Our Ref: R/101/10/

11th June 2010

Proposed garage and dropped kerb
37 Woodlands Avenue Rustington

FRONT ELEVATION 1:100

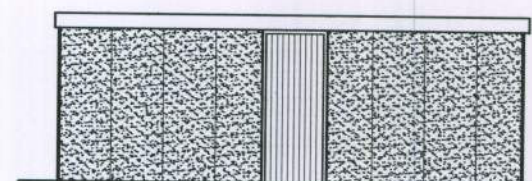
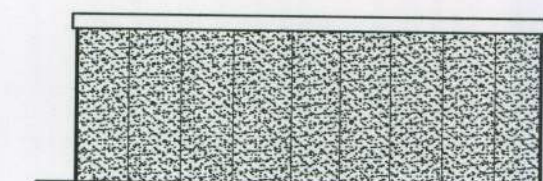
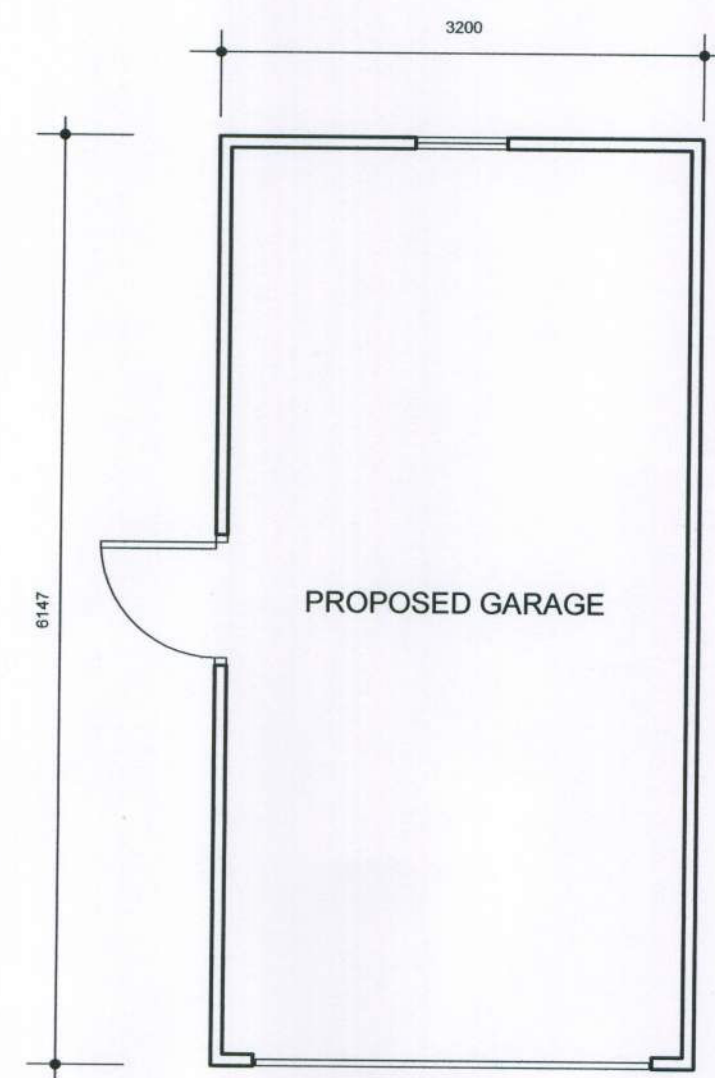
(ii) The proposed materials for the garage are inconsistent with the current brick built environment and would form an obtrusive feature which would be damaging to the visual amenities of both the neighbouring properties and the general aesthetics of the locality. ☐

BLOCK PLAN 1:500

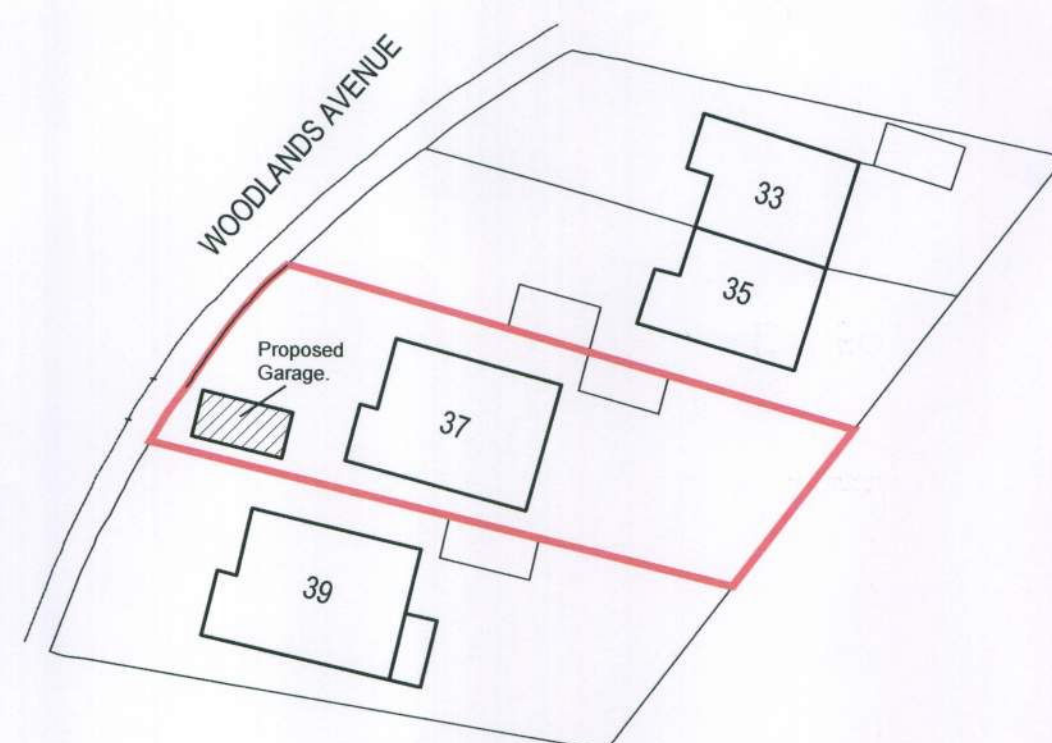
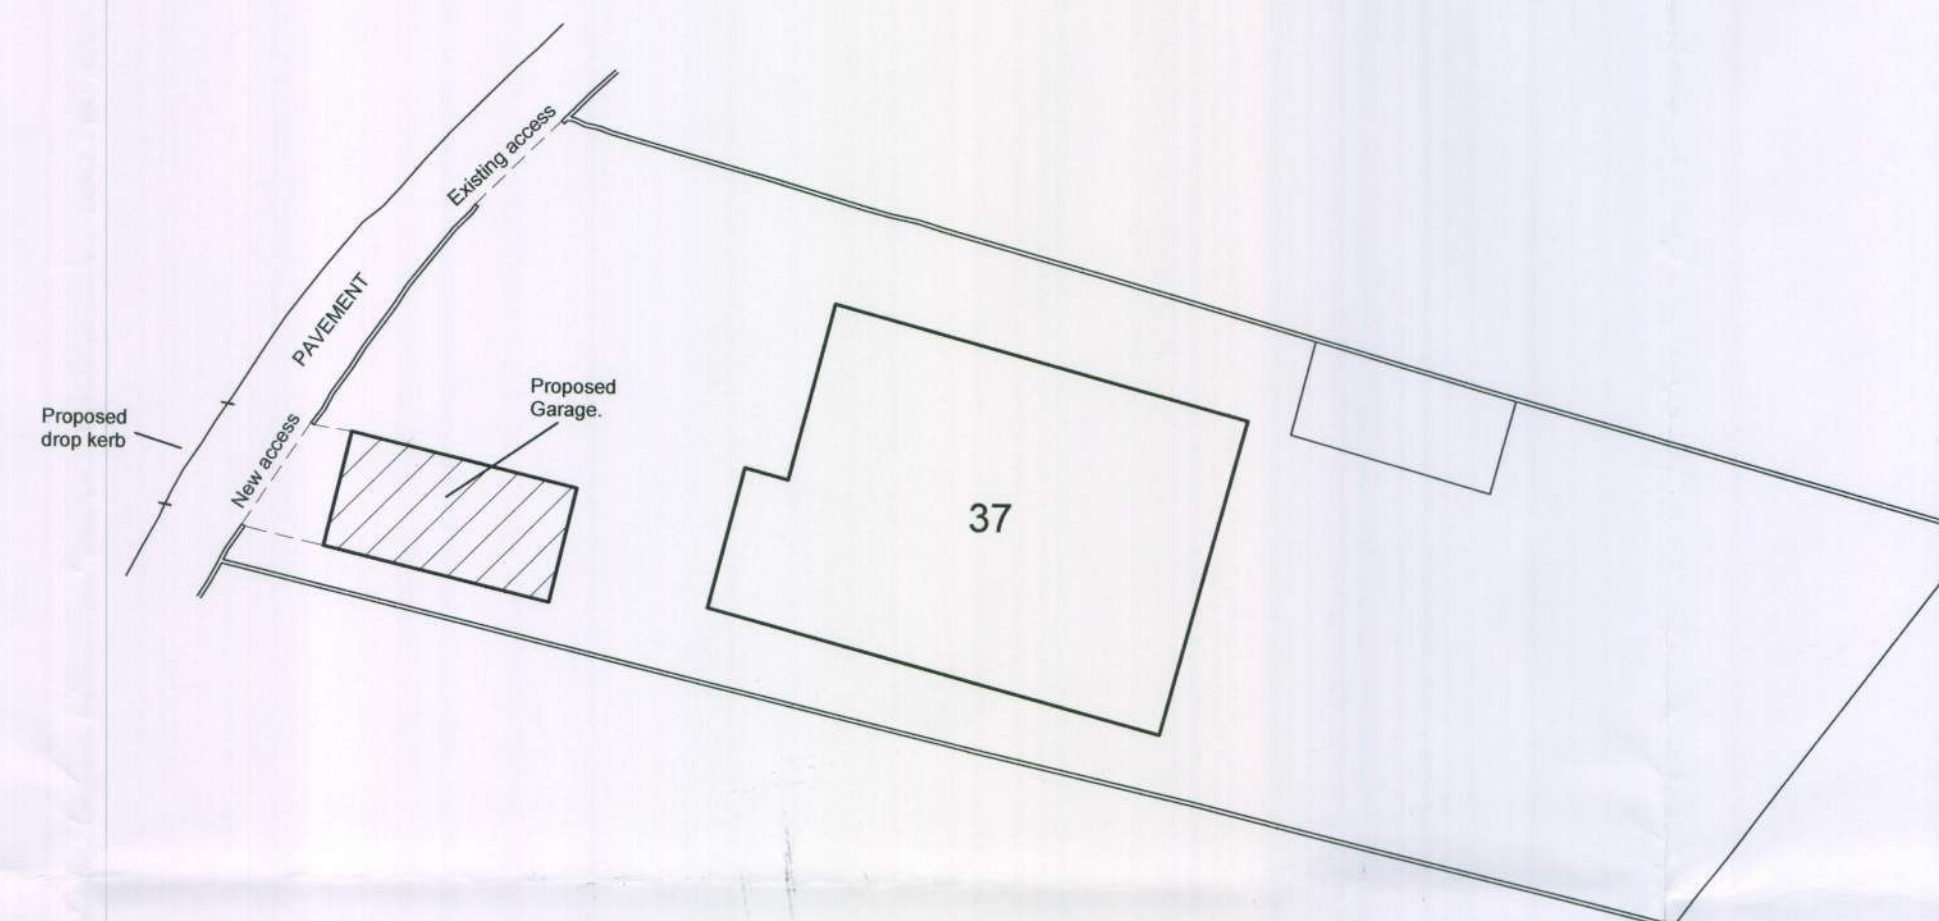
(i) The proposed location of the garage, in front of the building line, would be out of keeping with the surrounding area, and would most certainly be detrimental to the appearance of the street scene ☐
